Engineers Comments Regarding Surface Water Drainage

Application Reference:	AL/6/25/DOC	Reviewer Reference:	ADC/SB
Planning Officer:	Hannah Kersley	Date of Review:	21/02/2025
Site Name:	8 Autumn Gate Hook Lane Aldingbourne PO20 3TE		
Application Description:	Approval of details reserved by condition imposed under reference AL/75/24/HH relating to condition number 4 - surface water drainage scheme.		
Assessment Number:	1 of 2

Response	Condition 4: Objection
-----------------	-------------------------------

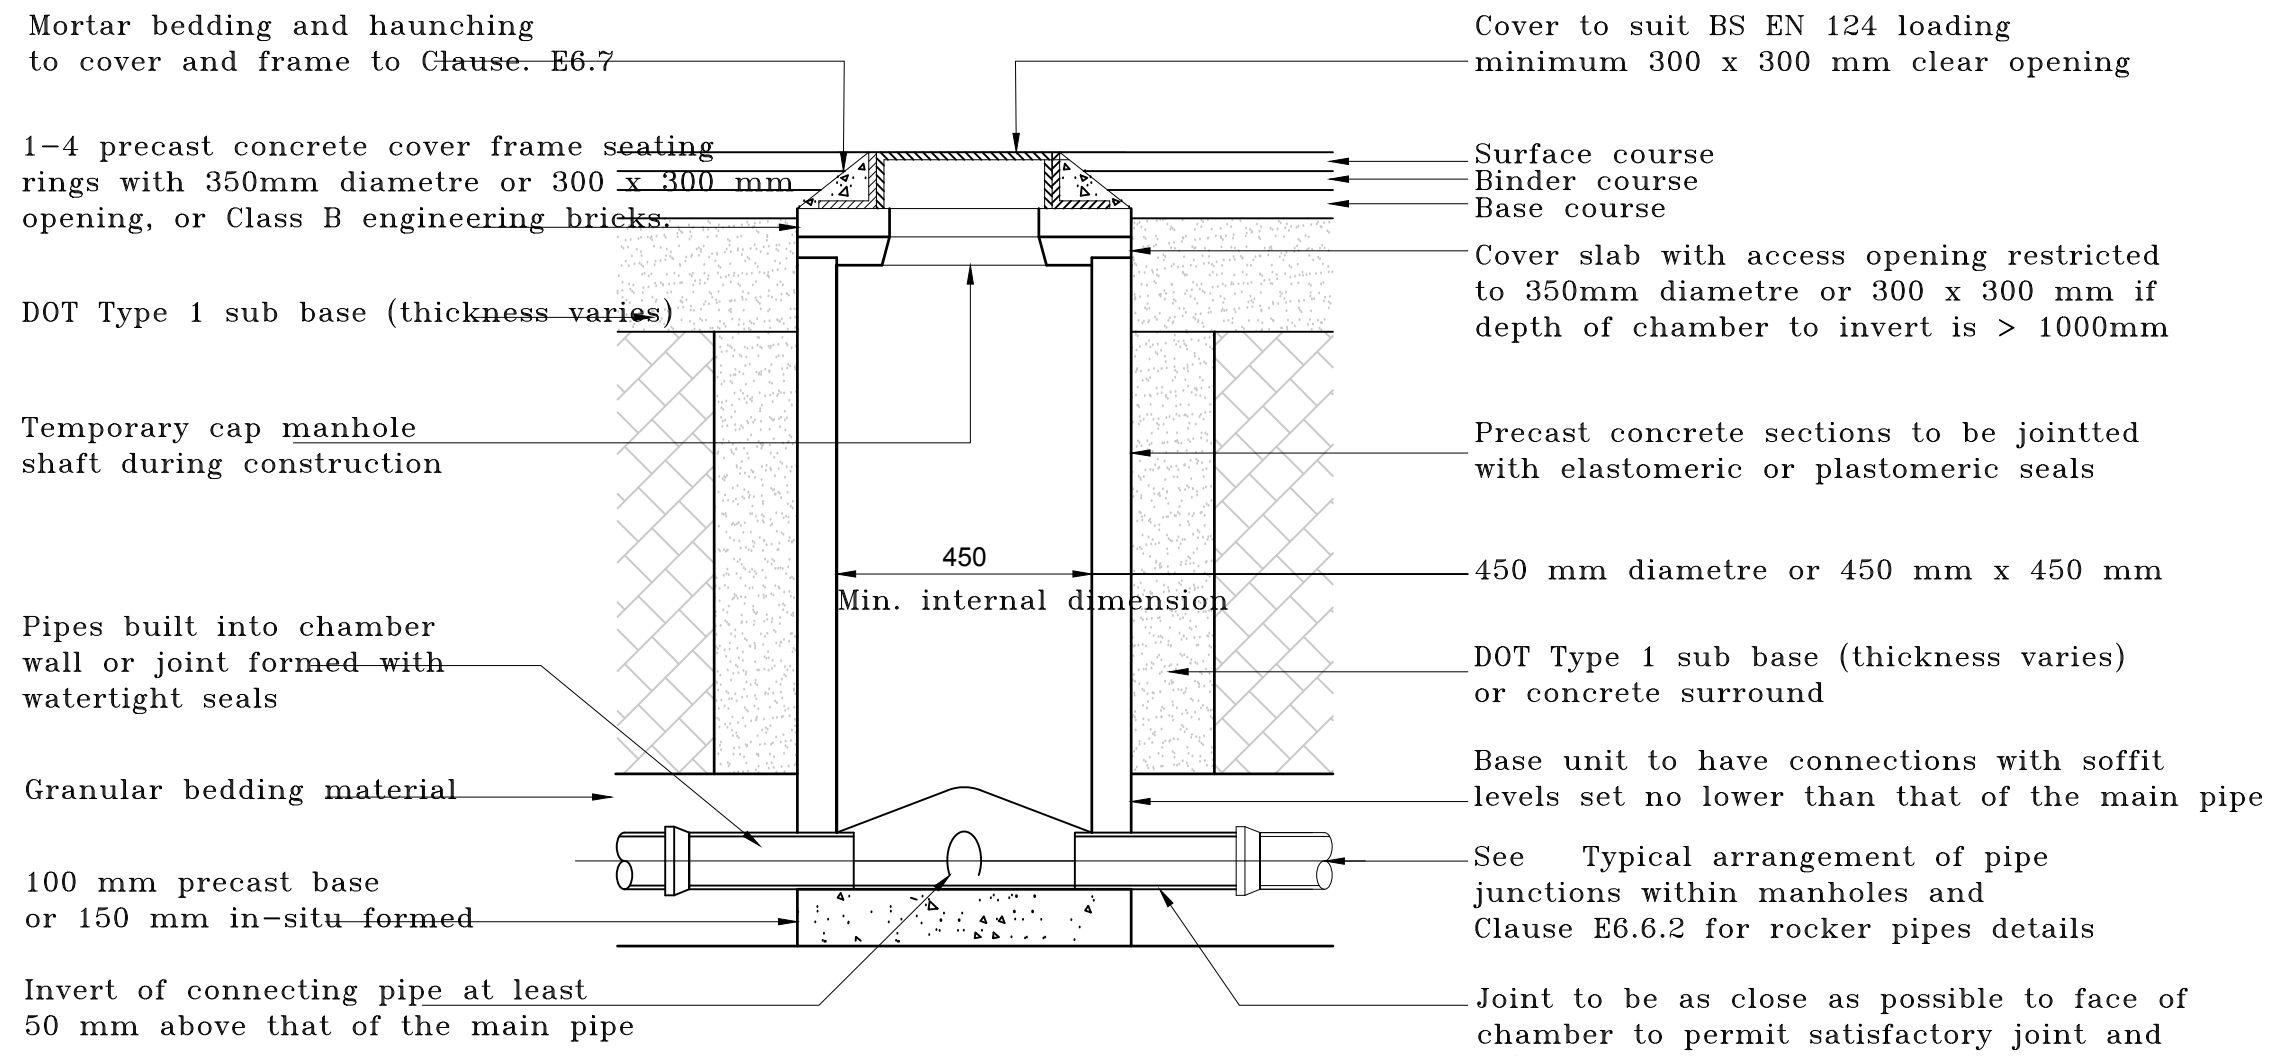
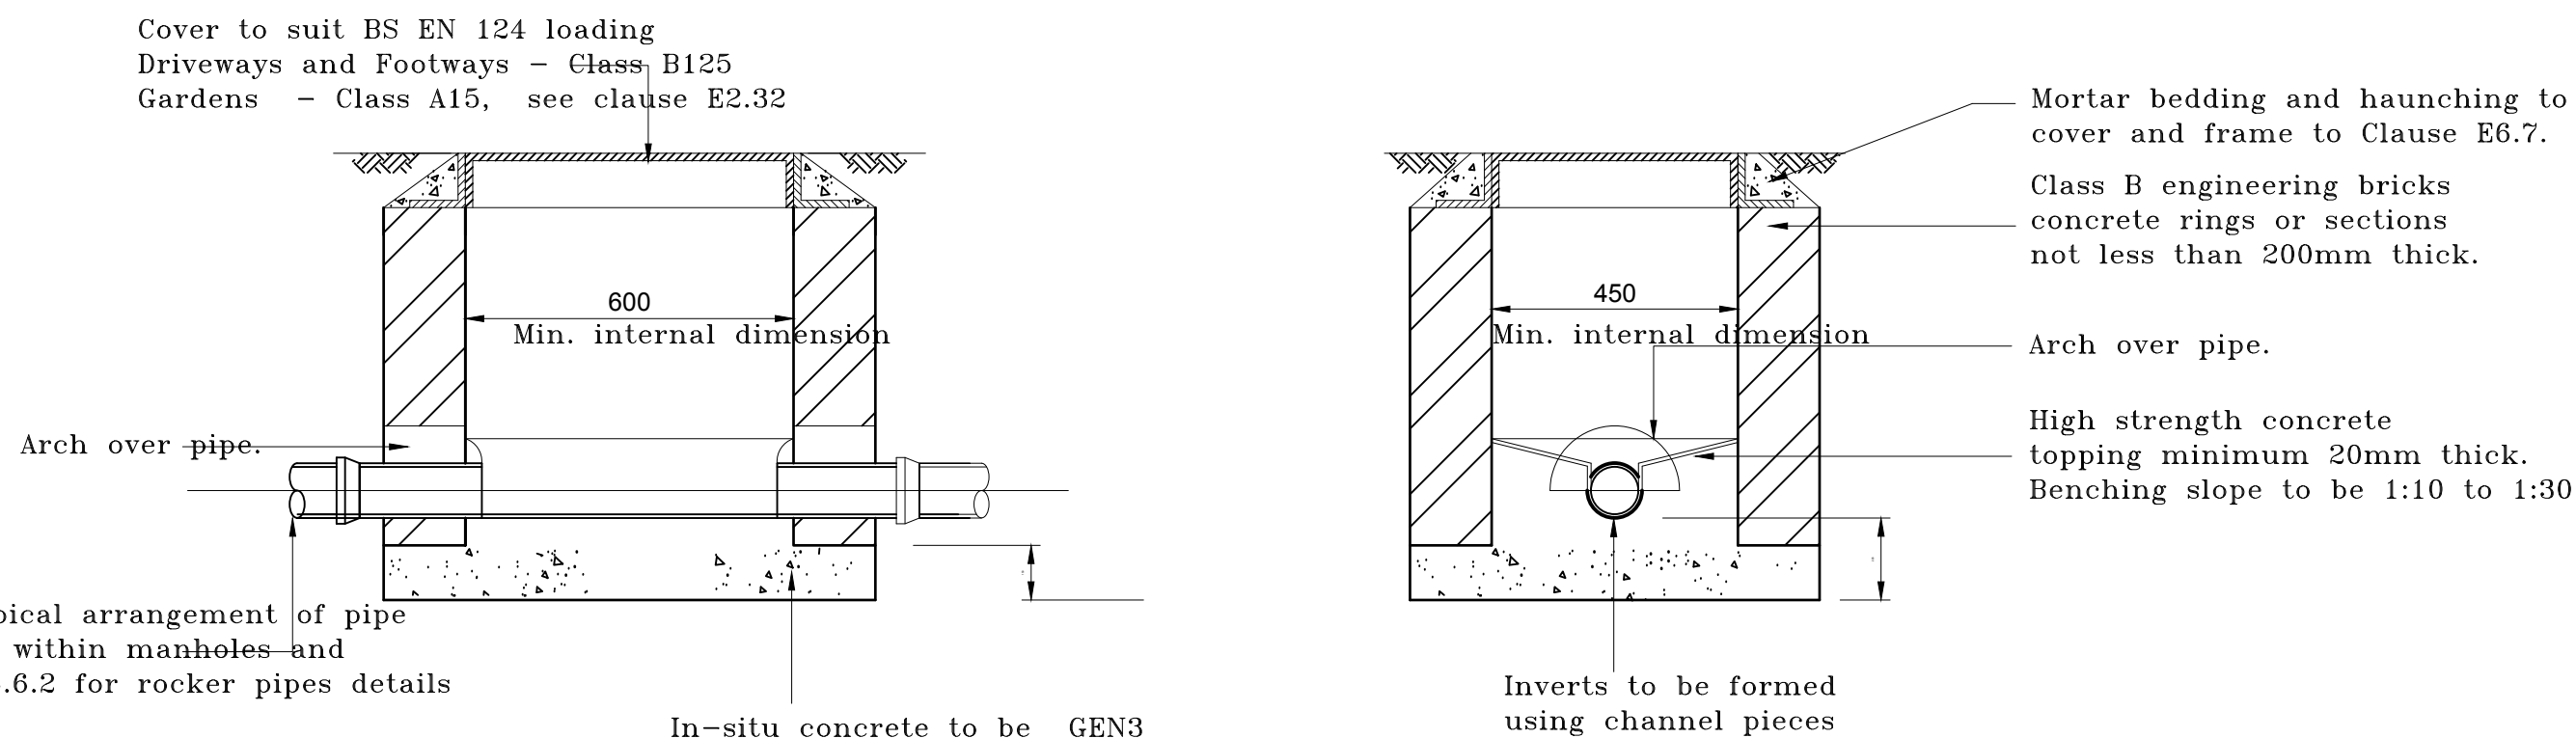
- Groundwater Monitoring Letter Report Ref GWPR4064
- Ordinary Watercourse Land Drainage Consent number LDC/ARUN/2021/013
- 435050-202 Rev P2 – Drainage Layout 2 of 2 – **the approved plan is a later revision [P5]**
- 435050-203 Rev P4 – Drainage Details 1 of 2
- 435050-204 Rev P – Drainage Details 2 of 2
- 435050-205 Rev P2 – Ditch Sections
- 435050-206 Rev P1 – Headwall Details – **the approved plan is a later revision [P2]**
- SW Network (Surcharged Outfall) dated 06/10/2021
- SW Network (435050 – FLOW SW) dated 28/08/2021
- SuDS Maintenance & Management Plan ref TB/435050/eg dated 11 October 2021
